OXFORDSHIRE COUNTY COUNCIL'S UPDATED RESPONSE TO CONSULTATION ON THE FOLLOWING DEVELOPMENT PROPOSAL

Application No: 19/02550/F-2

Proposal: Redevelopment of part of golf course to provide new leisure resort (sui generis) incorporating waterpark, family entertainment centre, hotel, conferencing facilities and restaurants with associated access, parking and landscaping

Response date: 3rd March 2020

Indicative Mitigation Works

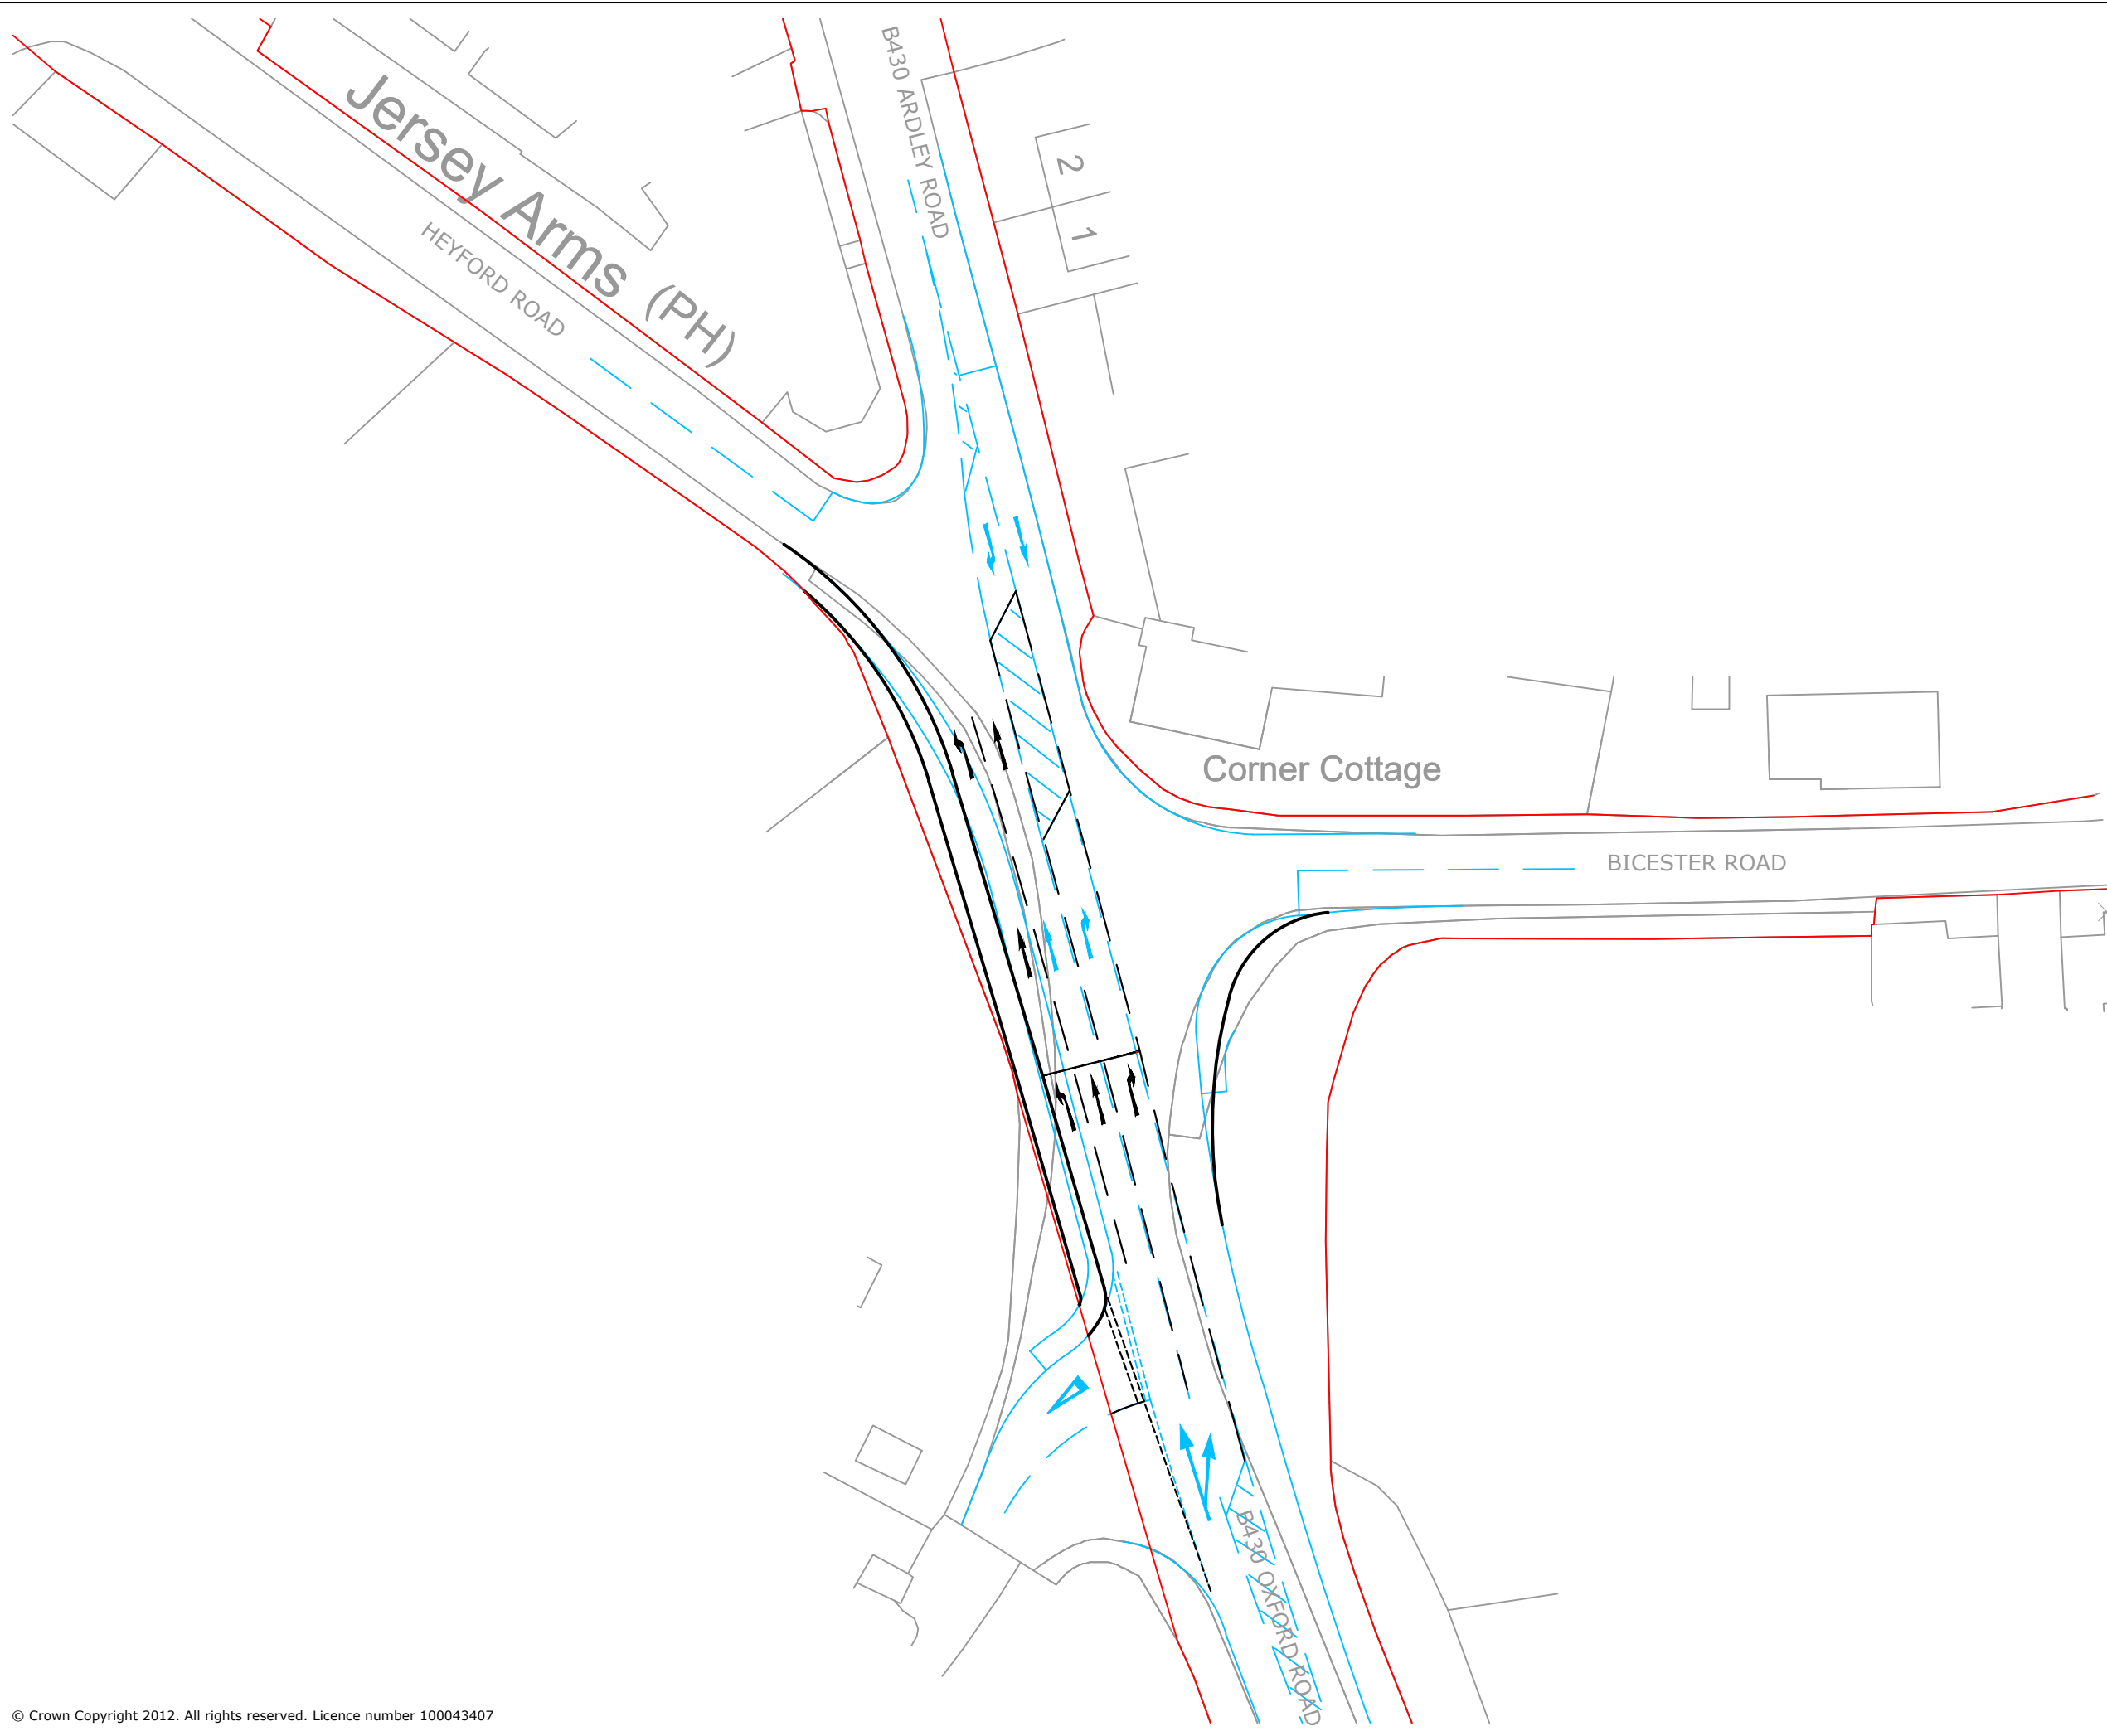
The County Council maintain their objection to the application as the mitigation scheme at Middleton Stoney suggested by Motion is not considered to be deliverable.

Motion have submitted to OCC indicative proposals for modifications to the consented highway works scheme at the B430/B4030 Middleton Stoney signalised junction. This scheme is to mitigate the effect of the first phase of the Heyford Park development. The intention of the proposed modifications is to further increase capacity at the junction to mitigate for the additional Great Wolf traffic. Following a preliminary review, OCC have fundamental concerns, meaning that the proposals are considered as undeliverable. The objection to the scheme is therefore maintained on this basis.
